RE WORTLEY VILLAGE PLAN

Following our site meeting at Wortley Village on 20th October 2016. Please find attached the following drawings revised as per our onsite discussions.

JOB NO. 707
DRAWING NUMBER 02-02
REV P2

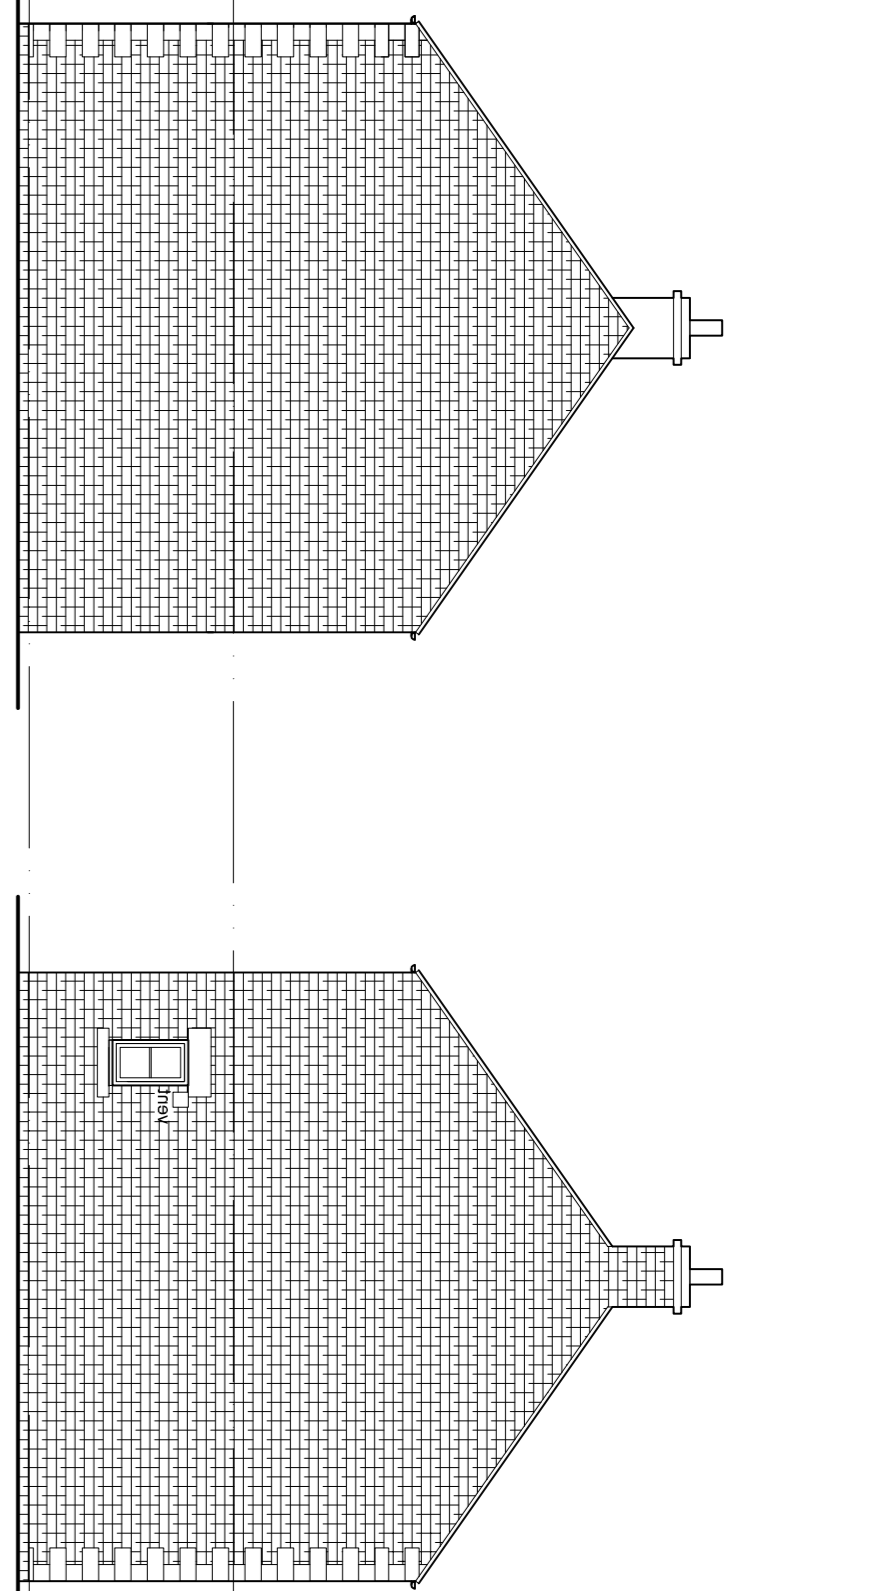
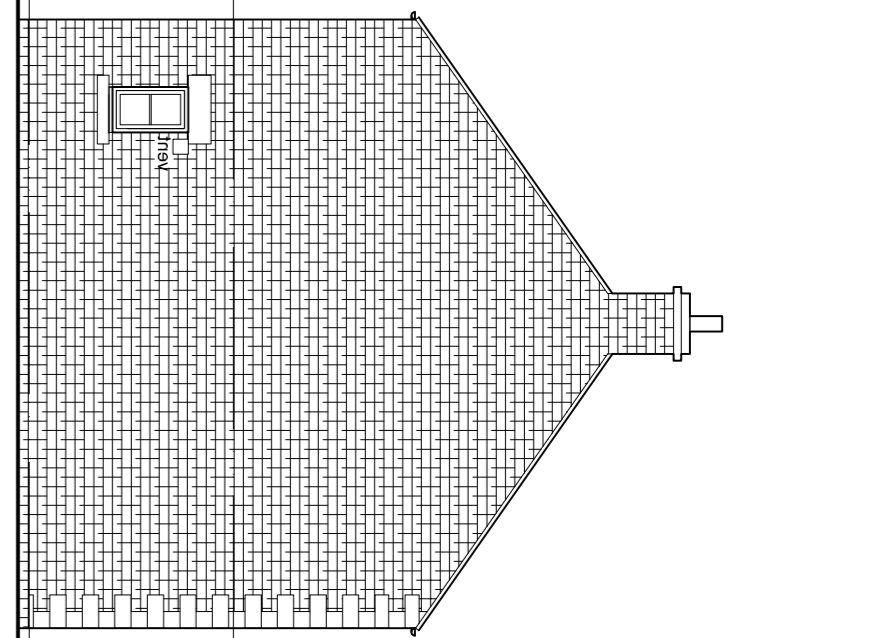
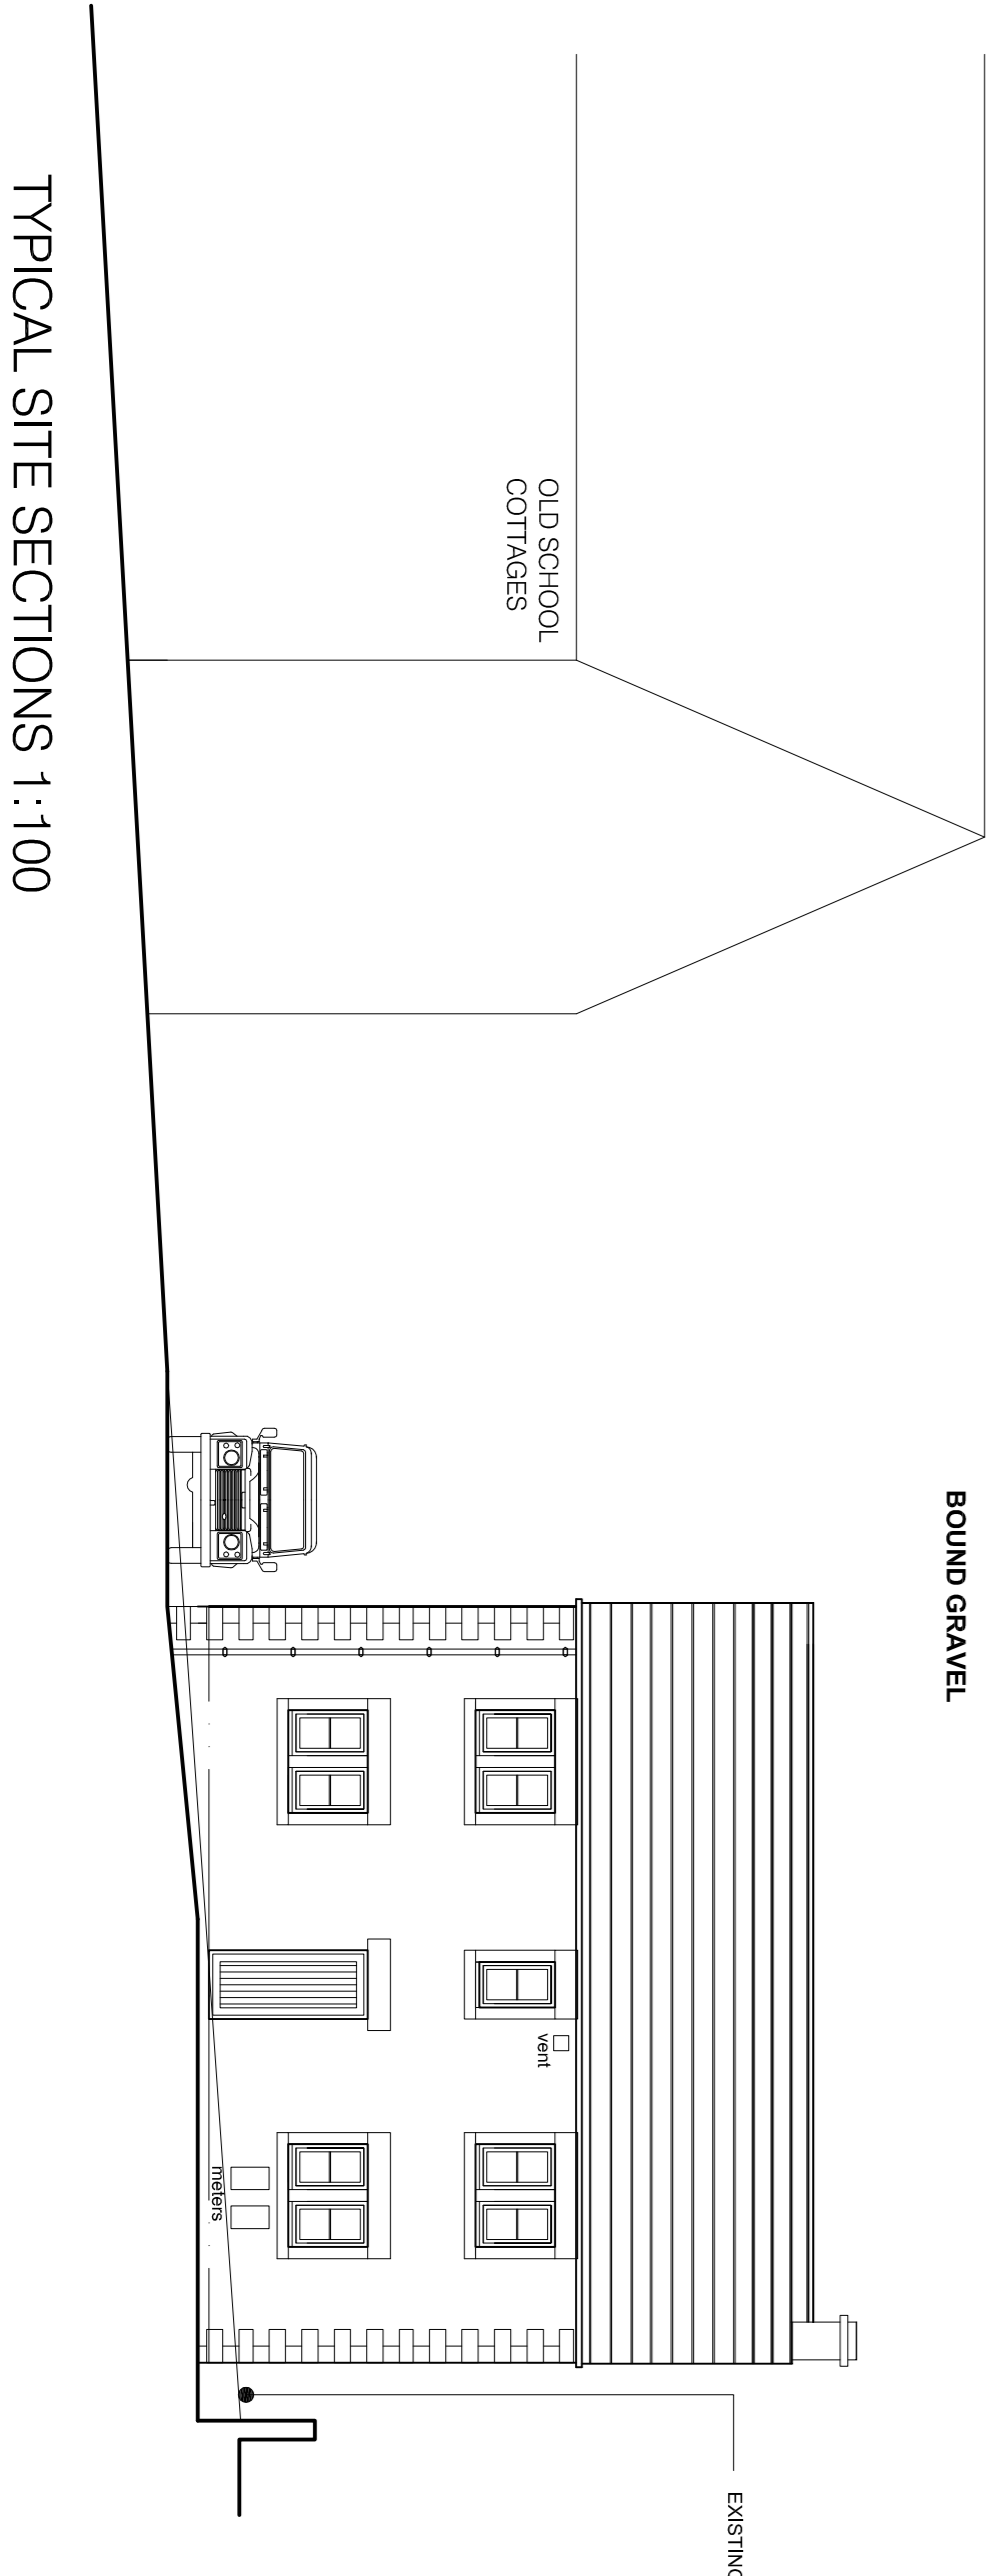
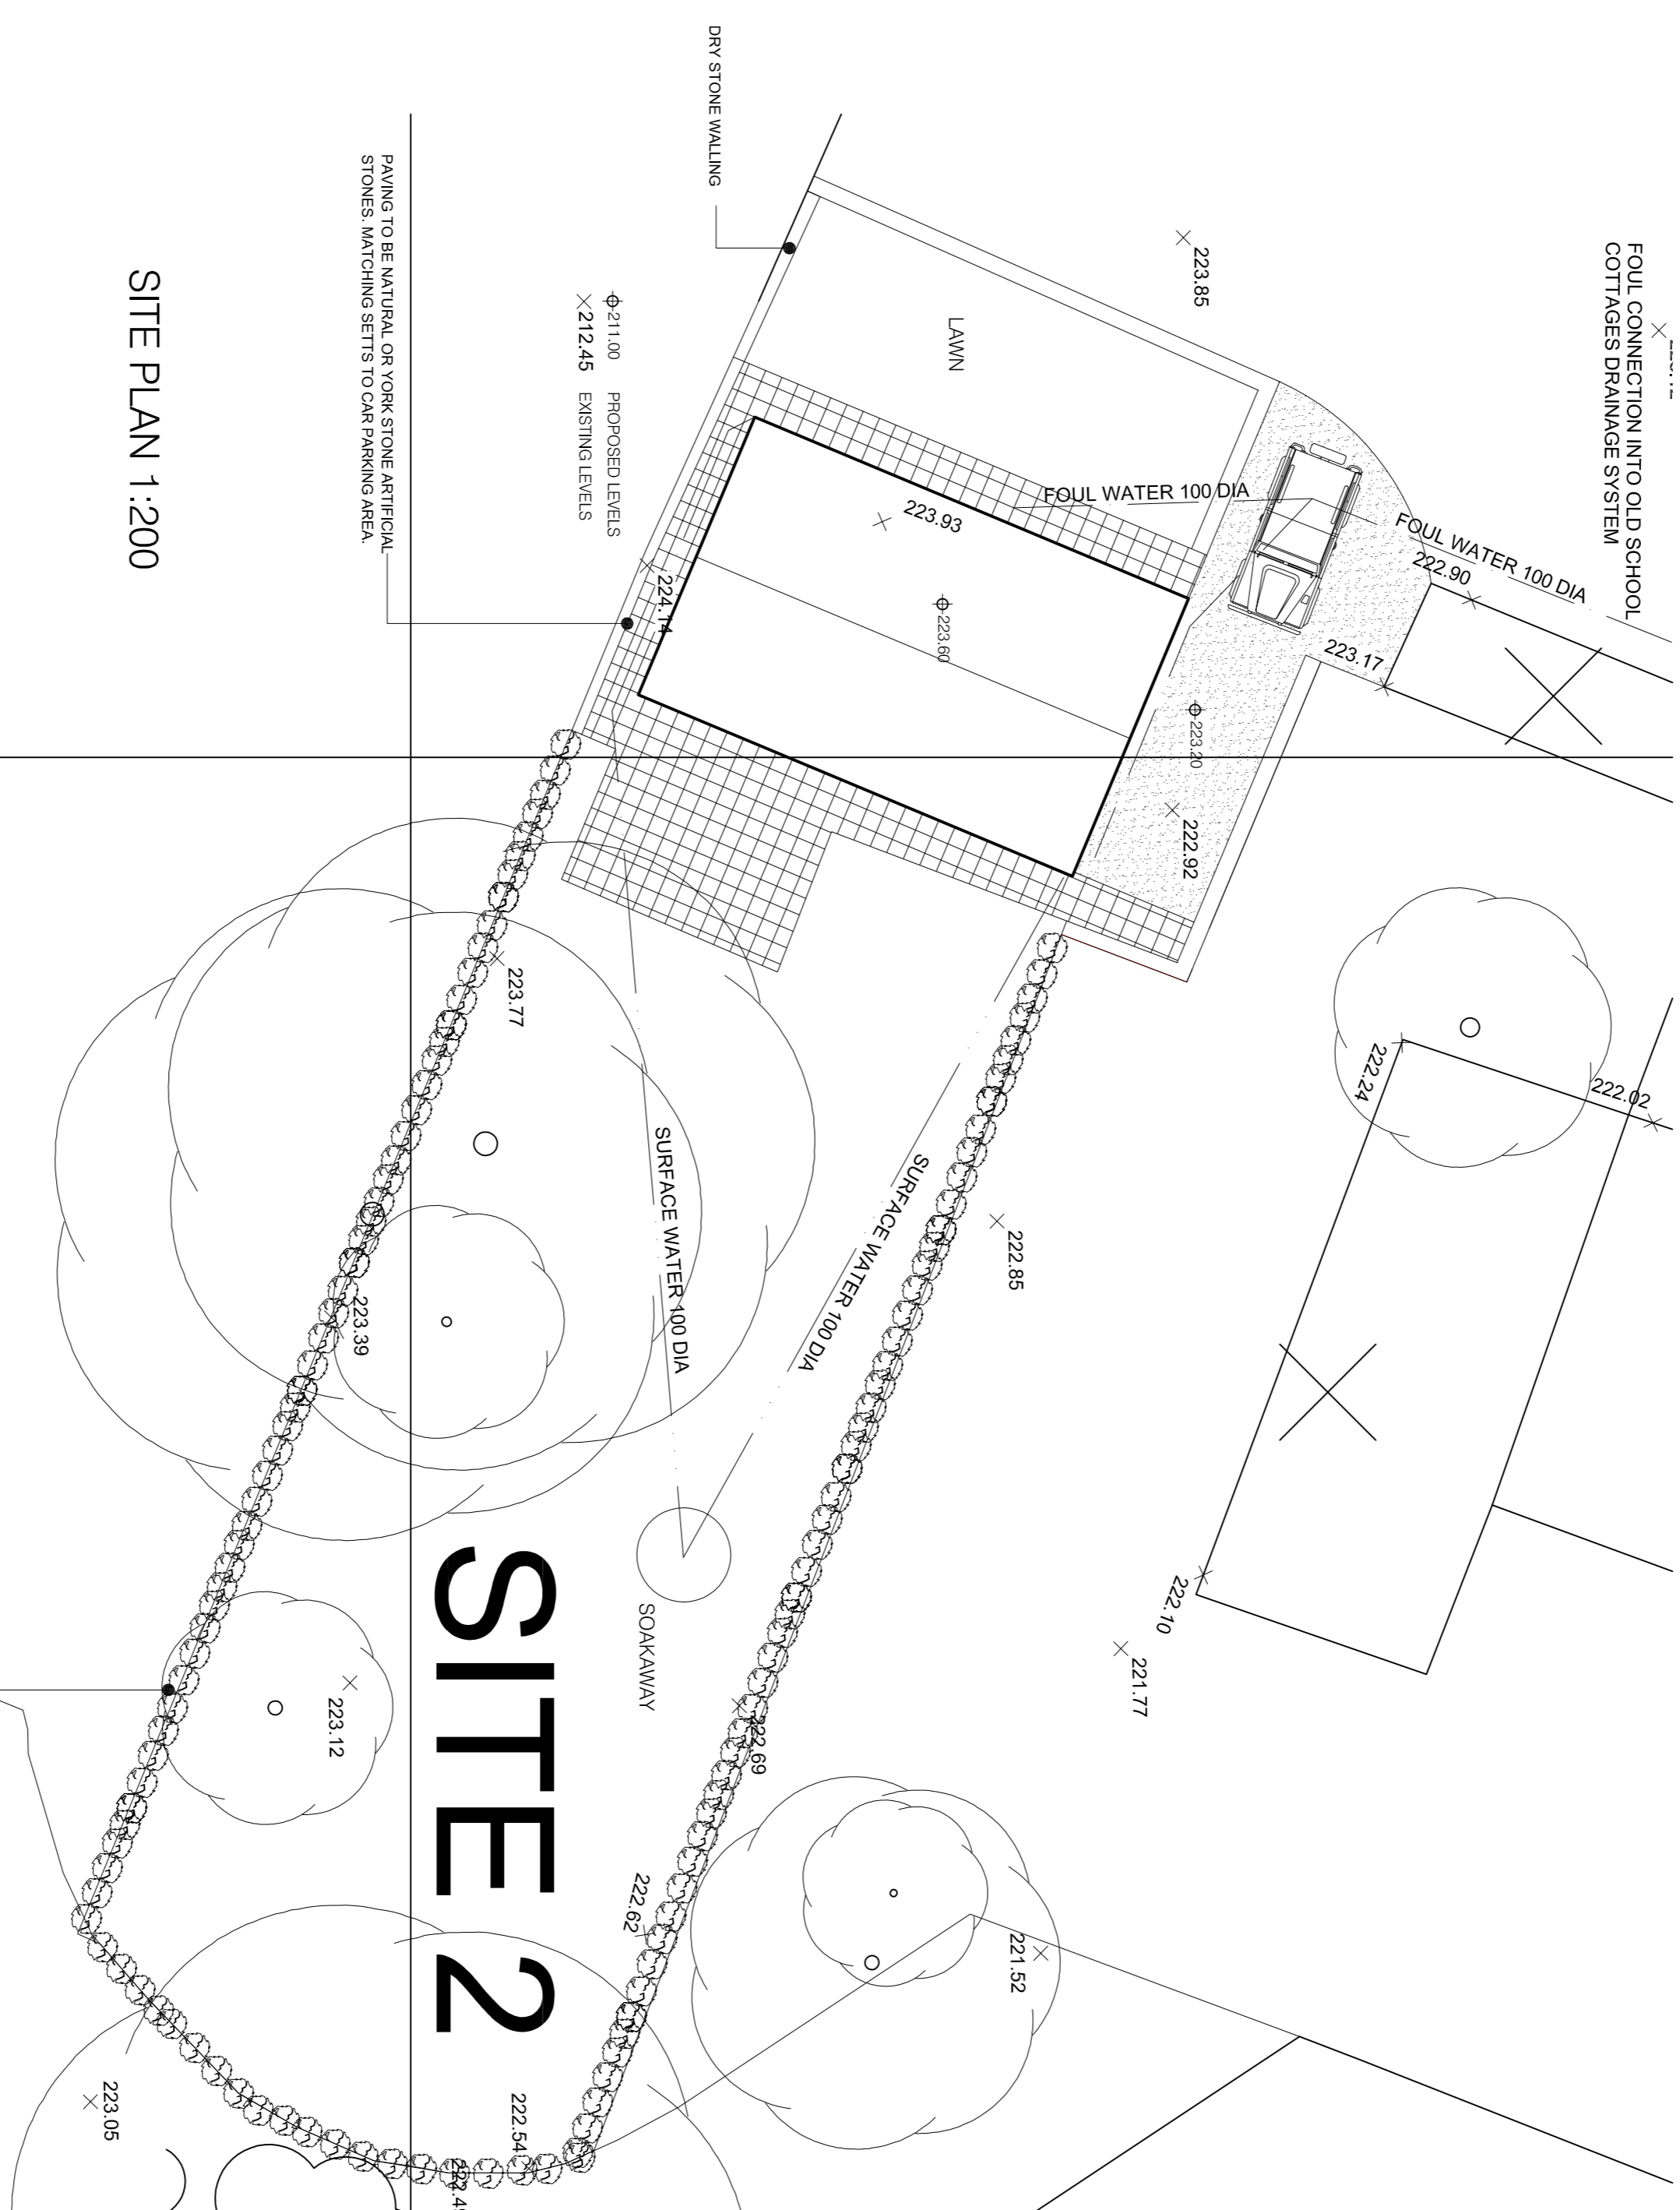
- 707-02-02-P2** Revised to confirm gutter details and roofing materials.
- 707-03-02-P2** Revised to confirm gutter details.
- 707-03-03-P1** Revised to confirm gutter details.
